From: stephen jupp [REDACTED]
Sent: 26 September 2019 16:15
To: Simon Davis <Simon.Davis@arun.gov.uk>
Cc: Anna Harper [REDACTED]
Subject: Fwd: Site 6, Chichester Road, Bersted

DRAWING TITLE
SITE LAYOUT - PHASE 4c

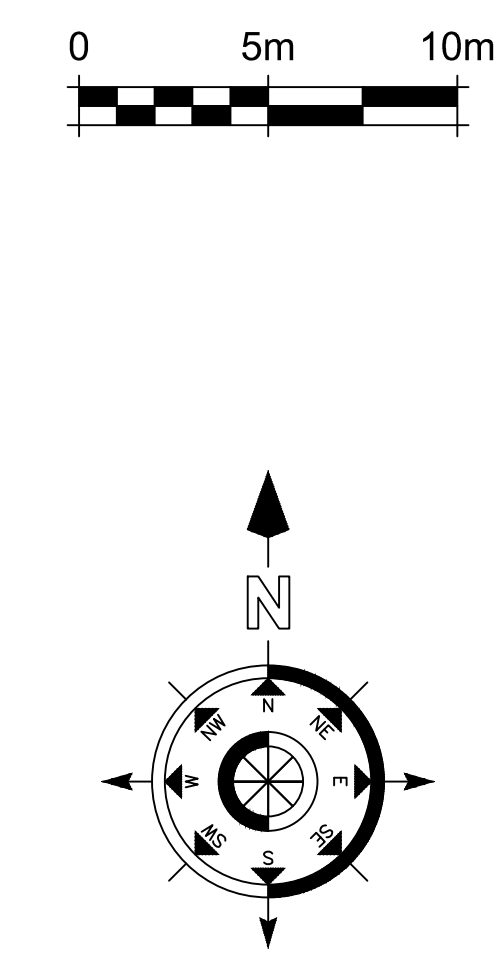
In addition the submitted drainage plan appears to show the removal of the corner of the landscape where the side and rear parts meet - this is unacceptable. i do not see why it needs 4 spaces and if 3 are required one could be adjacent to the garage.

This plot should also be moved 1.5m to the west to provide a 1.5m gap between its side wall and the hedge. Experience shows that the hedge will be removed in part to get the scaffold in otherwise. There is room to move it to the west

I also note that they have shown the new construction site compound.
As the brick yard is next to a house it is essential there are hours of use on this

In addition whilst tracking is shown in and out of the site onto the main road there is no internal tracking to demonstrate that a lorry can turn round on site.... this is essential

Status
for planning
Scale
1:200@A1
Job number
1526
Drawn
AR
Drawing number
L90-201
Date
Aug 2019
Revision
A

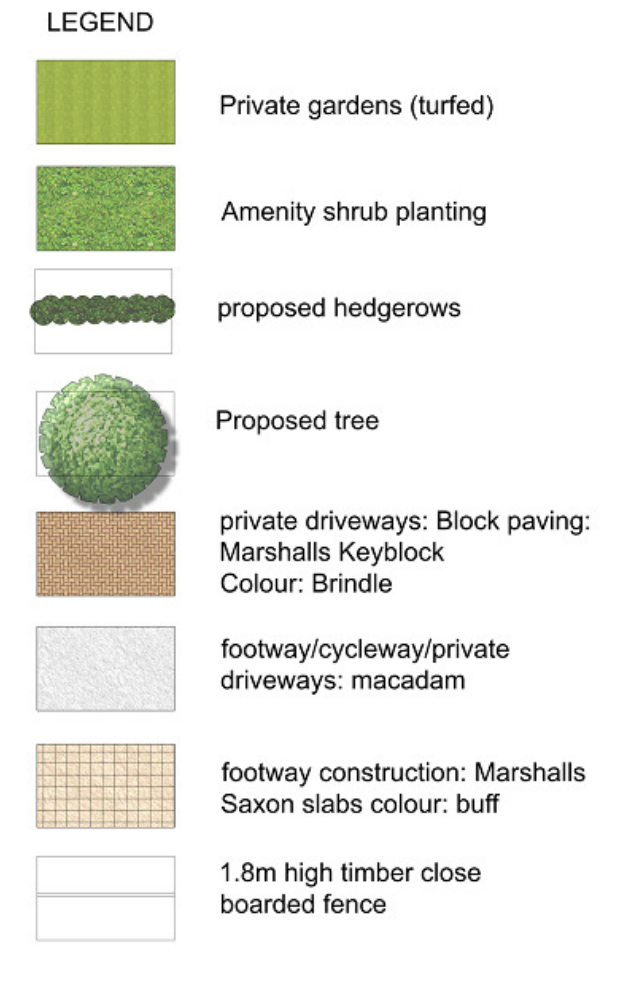
have amended plans been submitted yet to show the correct width of the landscape hedge and also that it is NOT to be included within the curtilage of any property but is fenced off separately and remains the responsibility of the management company to maintain as currently occurs along with the rear hedge

drawing L90-201 Rev A seems to remain current but the drainage plan contradicts this plan
